**28 September 2021**

**COUNCIL SUBMISSION**

**NOTICE OF EXHIBITION OF RESPONSE TO SUBMISSIONS FOR THE WESTMEAD CATHOLIC COMMUNITY EDUCATION CAMPUS (2 DARCY ROAD, WESTMEAD)**

SITE PLAN
sheet

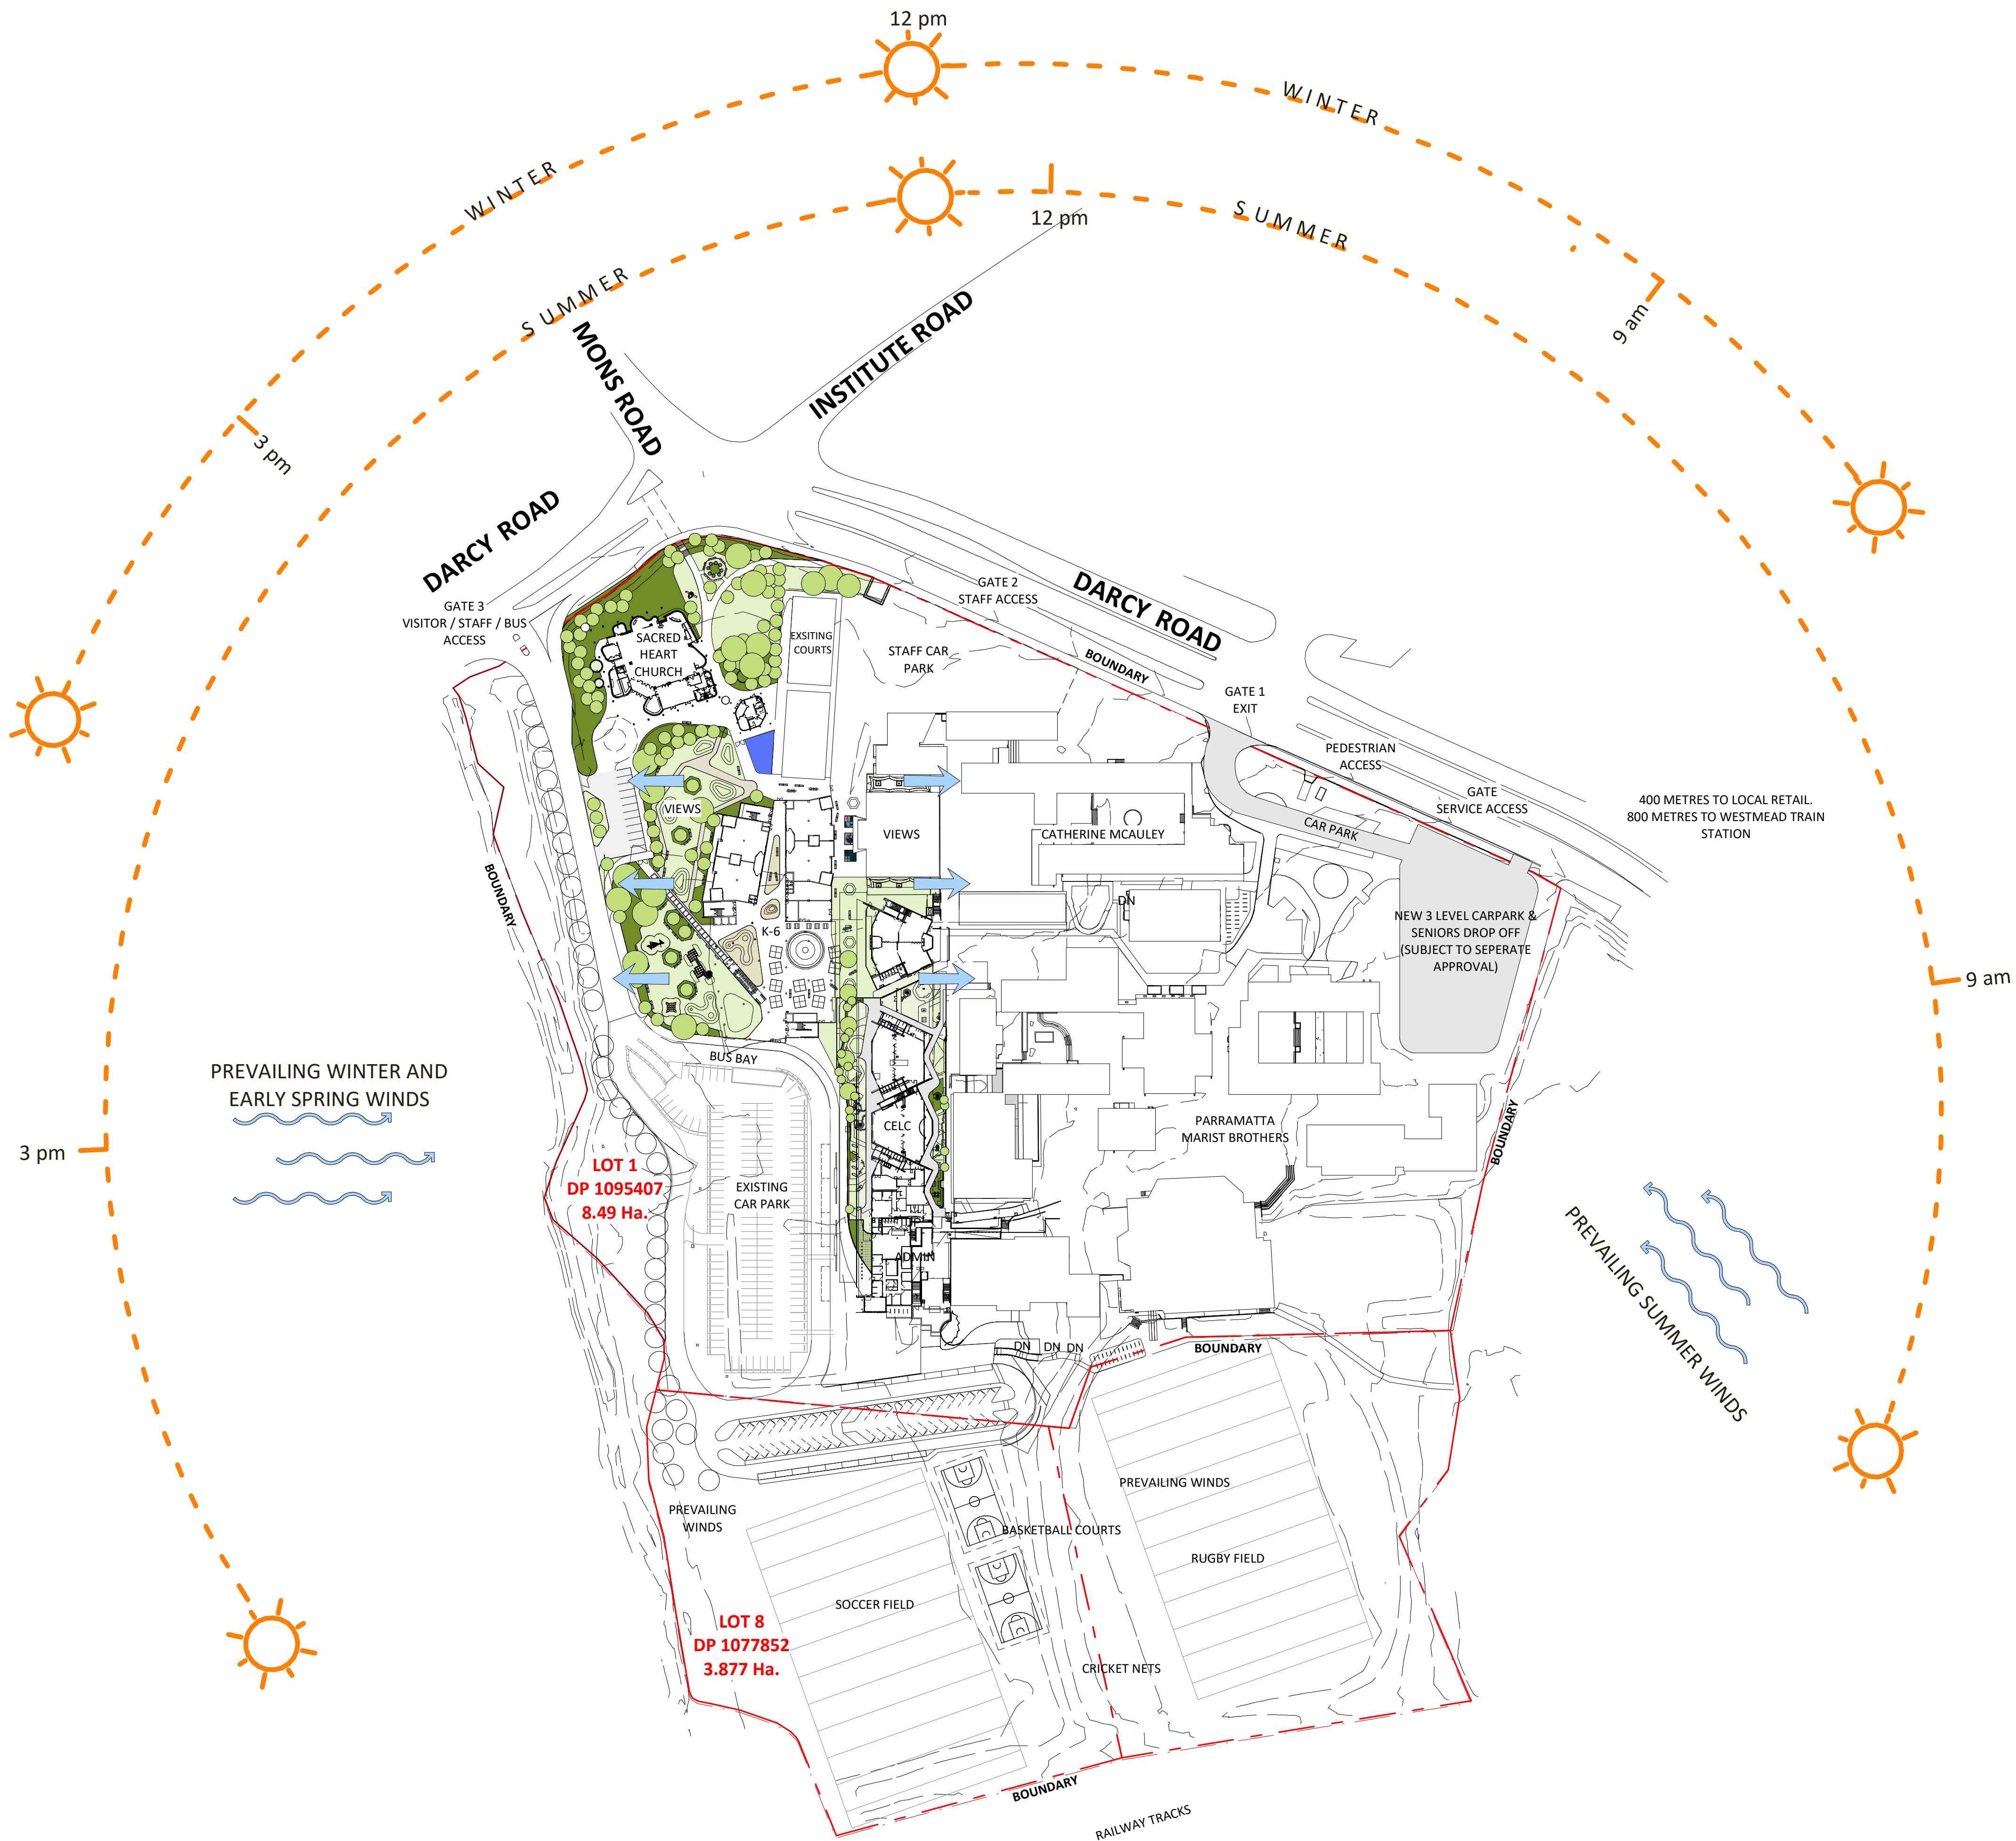
It is noted that the applicant has amended the proposal to include an upgraded link between the site and Farmhouse Road. This is welcomed and should be secured via condition.

As outlined above a pedestrian access across the site should be secured as part of this application. This may require a reorganisation of the proposed access from Farmhouse Road. It is considered that this could be managed via proposed conditions to secure the more complete access across the site.
